DECISION DELEGATED TO HEAD OF PLANNING

Application No: H08-0447-22 **Applicant:** Ms M Firth

Proposal: Proposed Barn Conversion - approved under H08-0428-20. Modification of Condition 2 to allow amendments to previously approved plans.

Location: Hazelwood Grange Hedgefield Hurn Gosberton

Drawing **Planning Elevations**

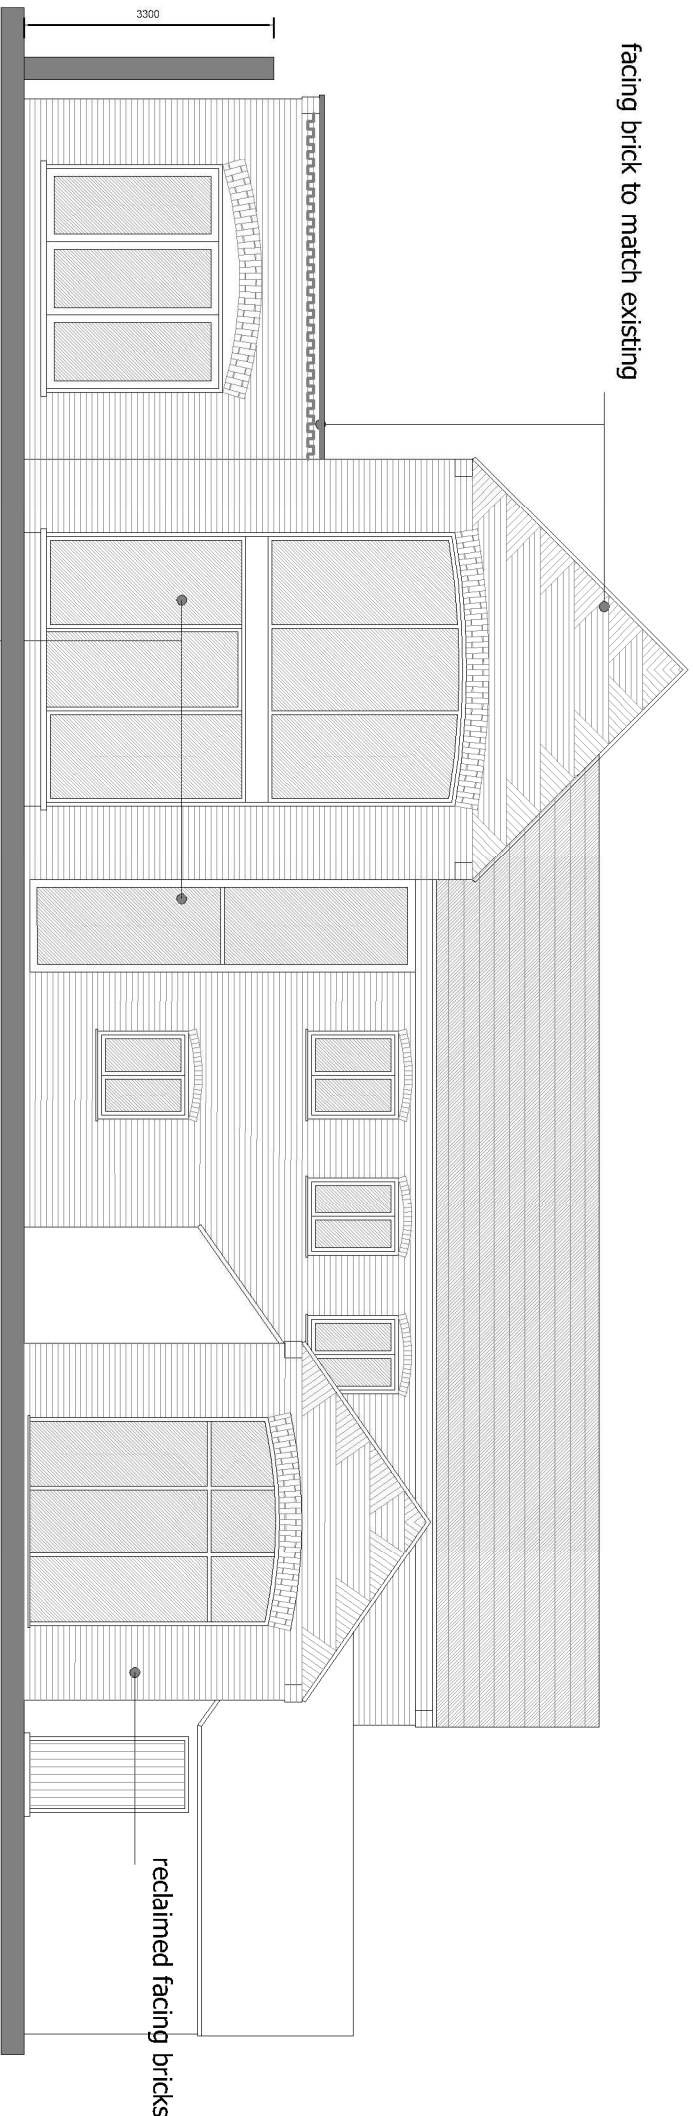
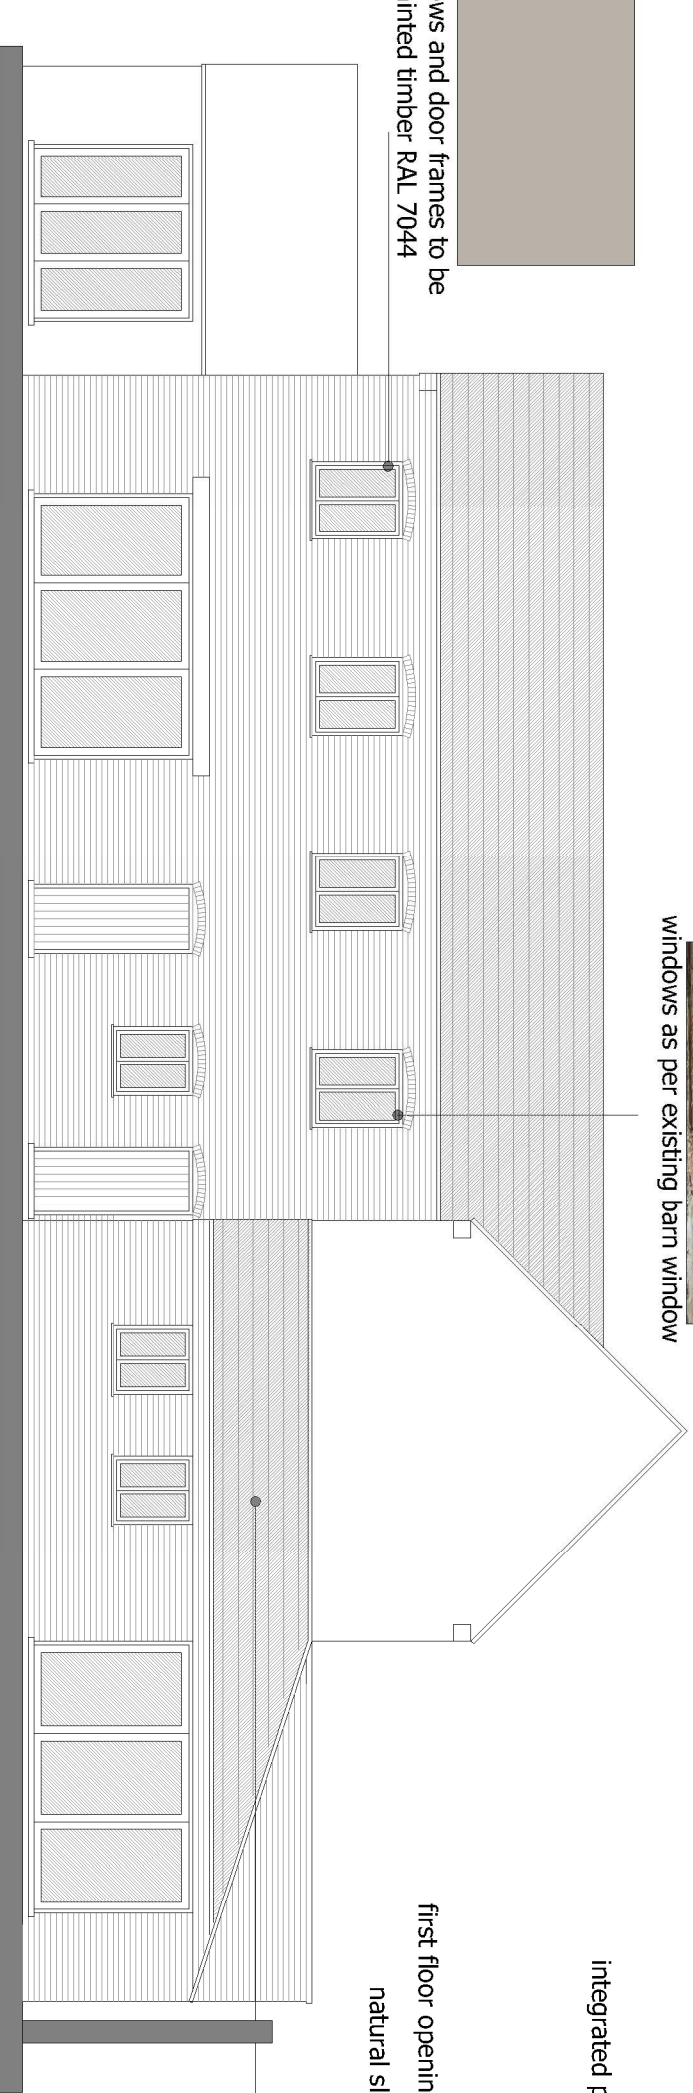
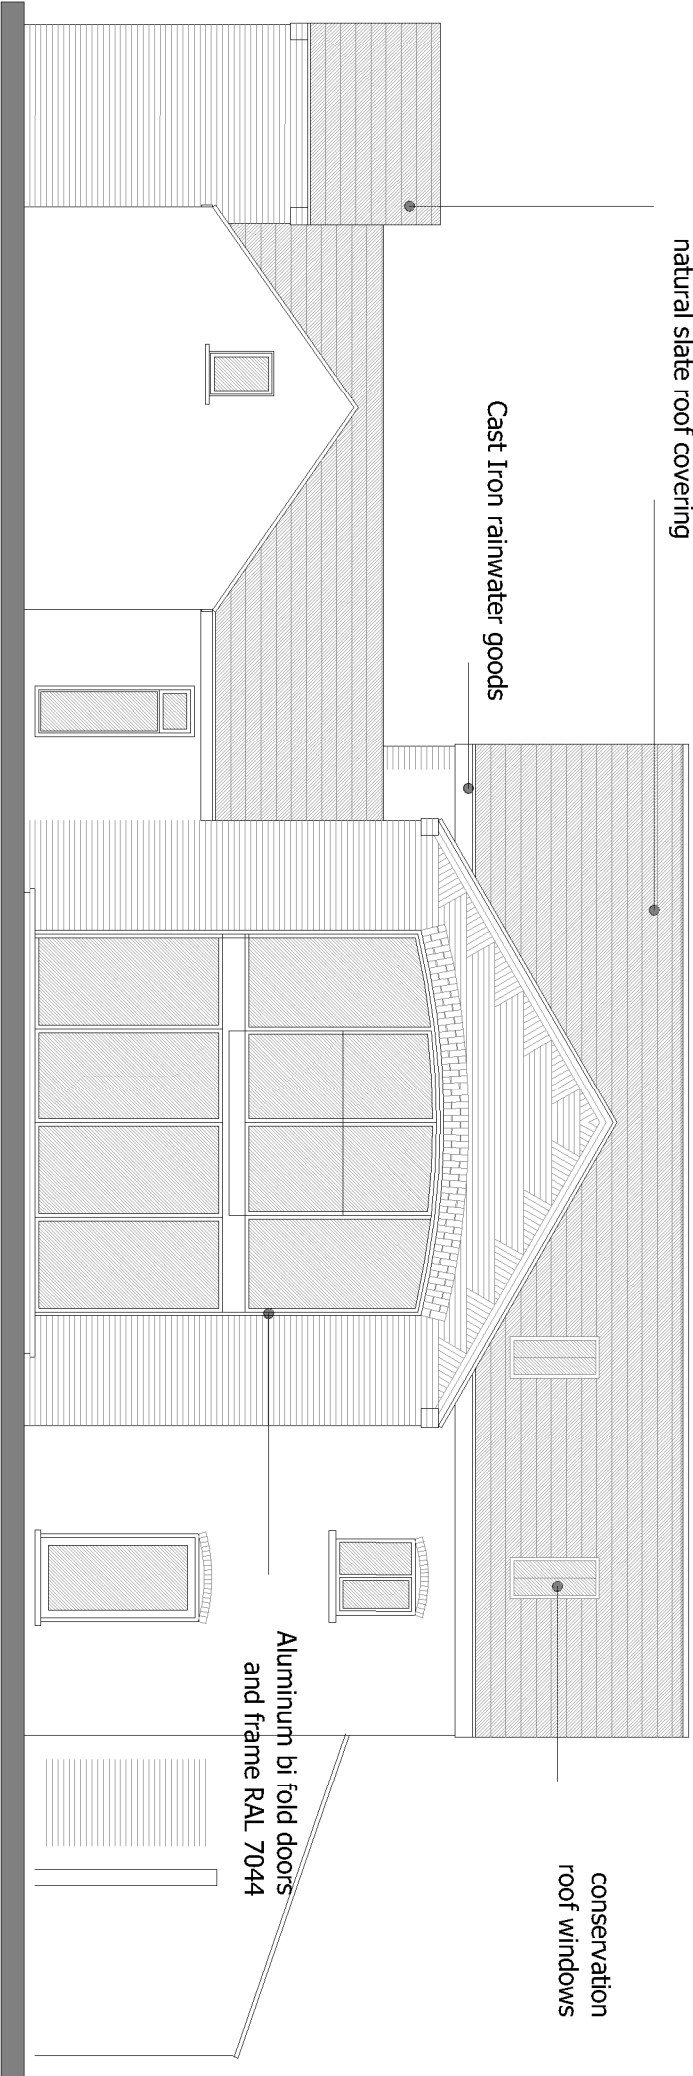
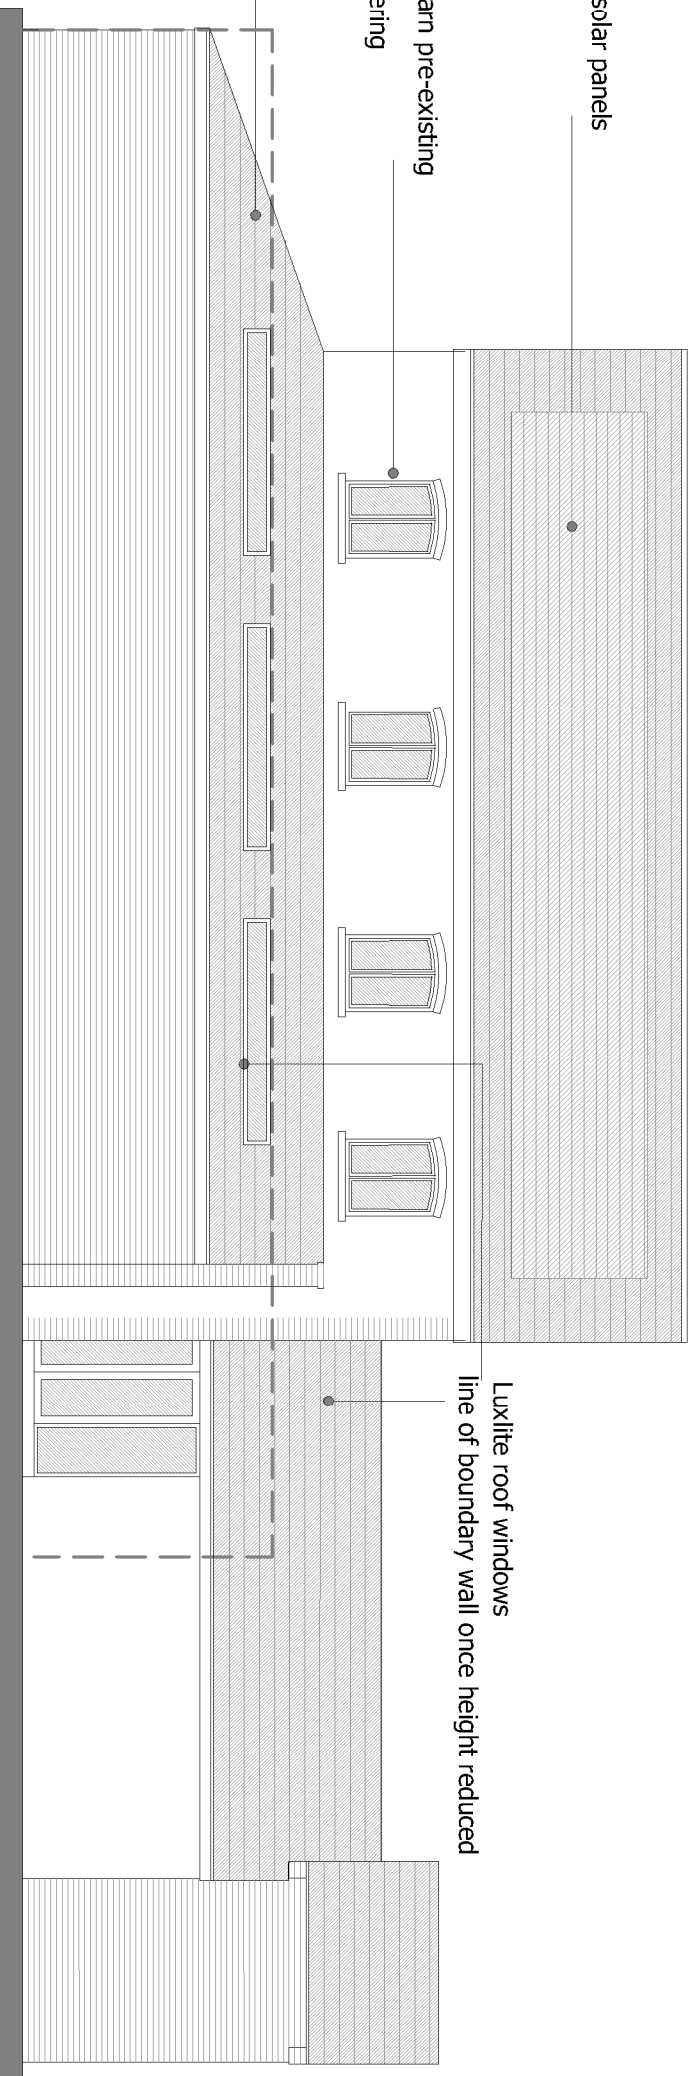
- Alteration to the Northern wing of the listed building to incorporate a higher roof with lead panelled surface, an exaggerated and enlarged east-projecting wing featuring with gable glazing with aluminium frame to replace the garage door, remove the previously agreed weatherboarding, reverted to brick with a traditional tumbled gable.

- reconfiguration of the proposed gable glazing to the east and North of the proposal from oak frame to aluminium powder coated, with fewer glazing sections.

- Alteration of the Southwestern 'cart shed' elevation roof pitch to include a wraparound pitch over to the northwestern elevation.

- Previously consented oak large gable glazed window/s were more appropriate to the listed building than the currently proposed aluminium powder coated units:

The alterations to the eastward projecting wing to the north of the site represent a design improvement over that which was approved previously. The applicant has been able to show that previously on site a wing of the building which was at the height of the proposed new ridgeline was extant, setting a historic precedent for this scale. Additionally, the tumbled gable and glazed gable-end are a marked visual improvement over the mock-garage style of the previously approved proposal.

The host property to this application is only a structure which is listed due to its association with Panton House at the time of listing. It is not itself mentioned in the listing description and therefore, it can be extremely difficult to ascertain what is considered to be the 'special interest' in this structure. Oak framed windows were seen as a highly positive feature of the proposed development, however, metal alternatives, are not deemed to be unacceptable in the context of this listed-by-association property, as metal windows, particularly with slim mullions, are not considered to be a form which is inappropriate to a historic-environment setting.

For the reasons set out above, on balance, this proposal is deemed to have a neutral impact upon the heritage asset. The large gable glazing sections would have been preferable in their originally agreed oak format. However, the proposed aluminium alternative is not unacceptable and the other proposed alterations are either minor or actually make improvements to the authenticity and design of the final proposal. For this reason, this application can be said to assist in conserving the Historic Environment in accordance with S16 of the National Planning Policy Framework (2021)
